REF: 23/02338/OUT

**Location: Land West Of Oxford Close And North Of
Corner Farm Station Road Kirtlington**

28 September 2023

Comments on outline plans provided

Drawing Title:
 PROPOSED
 SITE PLAN
 COLOUR
 (ILLUSTRATIVE)

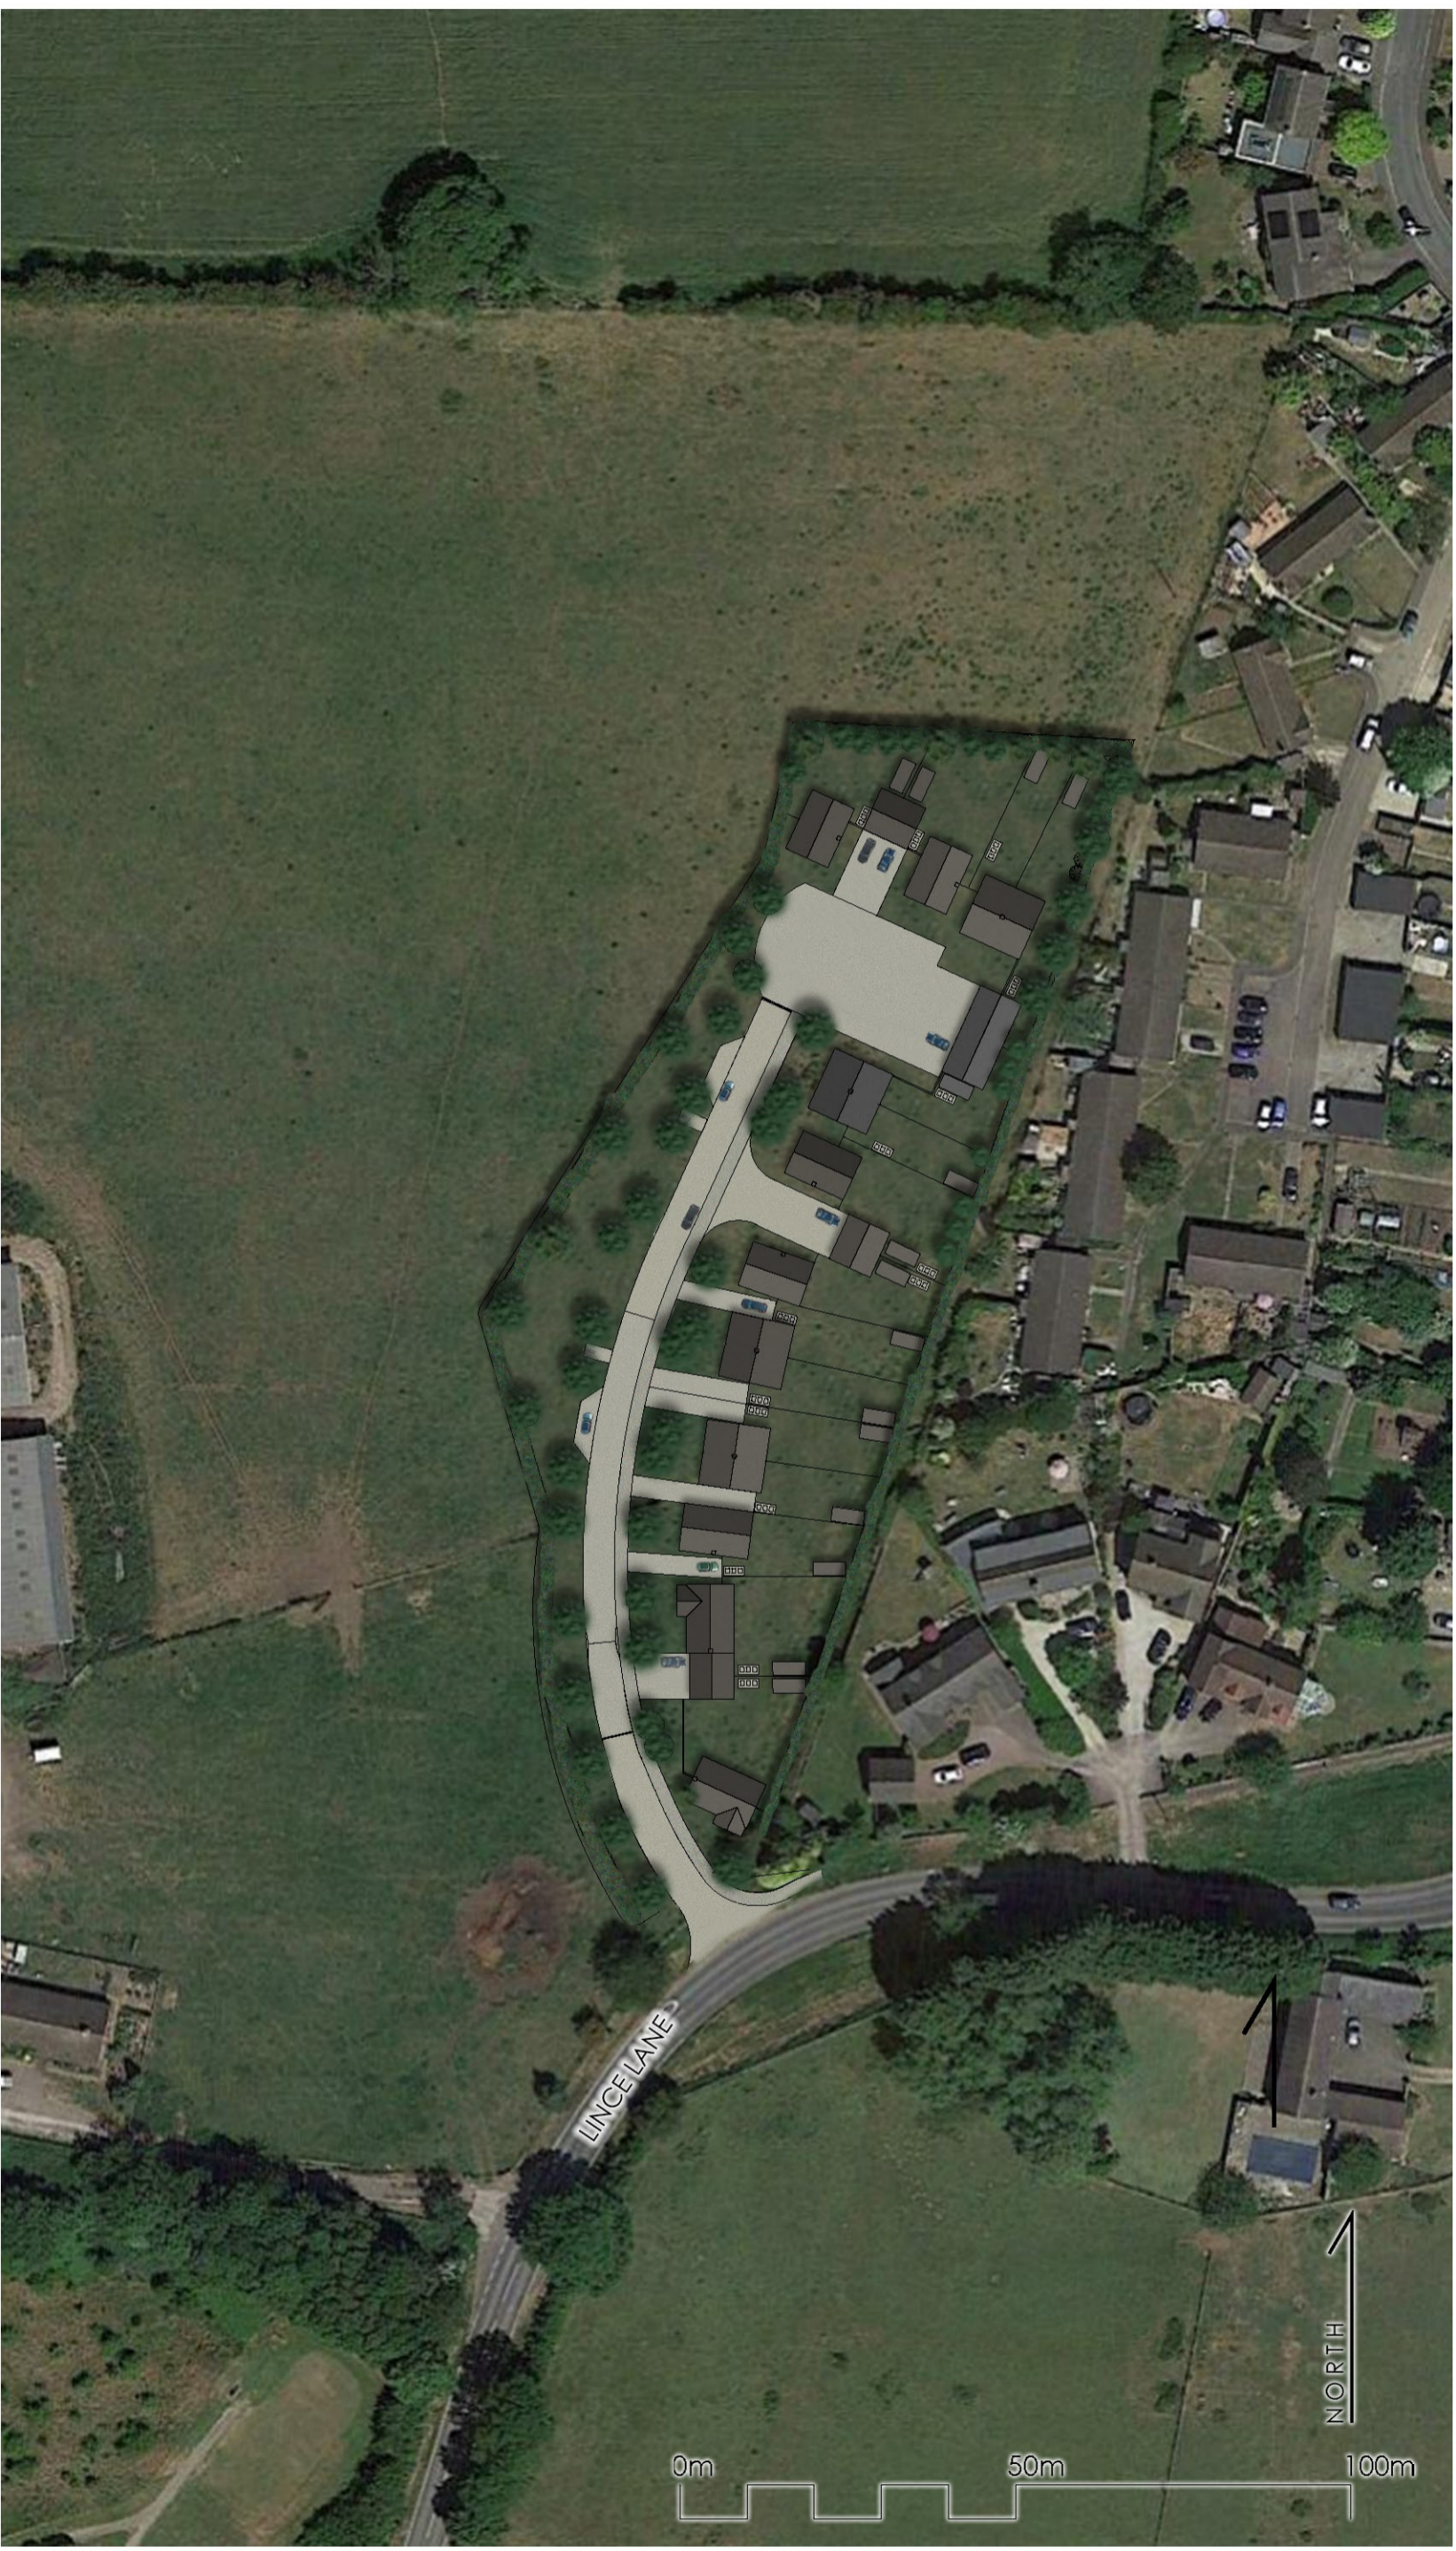
- Parking to the rear of the property as seen for plot 1 should be avoided as this removes surveillance over vehicles, leaving them vulnerable to crime. Vehicles should be directly overlooked by surveillance from the property that they serve.

- All in-curtilage parking should be overlooked by a window in the elevation overlooking parking, and this window should provide active surveillance from either the kitchen or living room of the dwelling.

- The site boundary adjoining existing development to the east must be designed in such a way as to prevent unauthorised access to the vulnerable side/rear garden boundaries of existing and proposed dwellings.

- All dwellings should provide surveillance with active frontage overlooking the development.
- The green space adjacent to the road has no clear function or purpose – is this usable green space or ecological mitigation? The design of the green space should clearly identify its purpose – including some informal play equipment would be beneficial to activate the space and identify it as usable public open space.
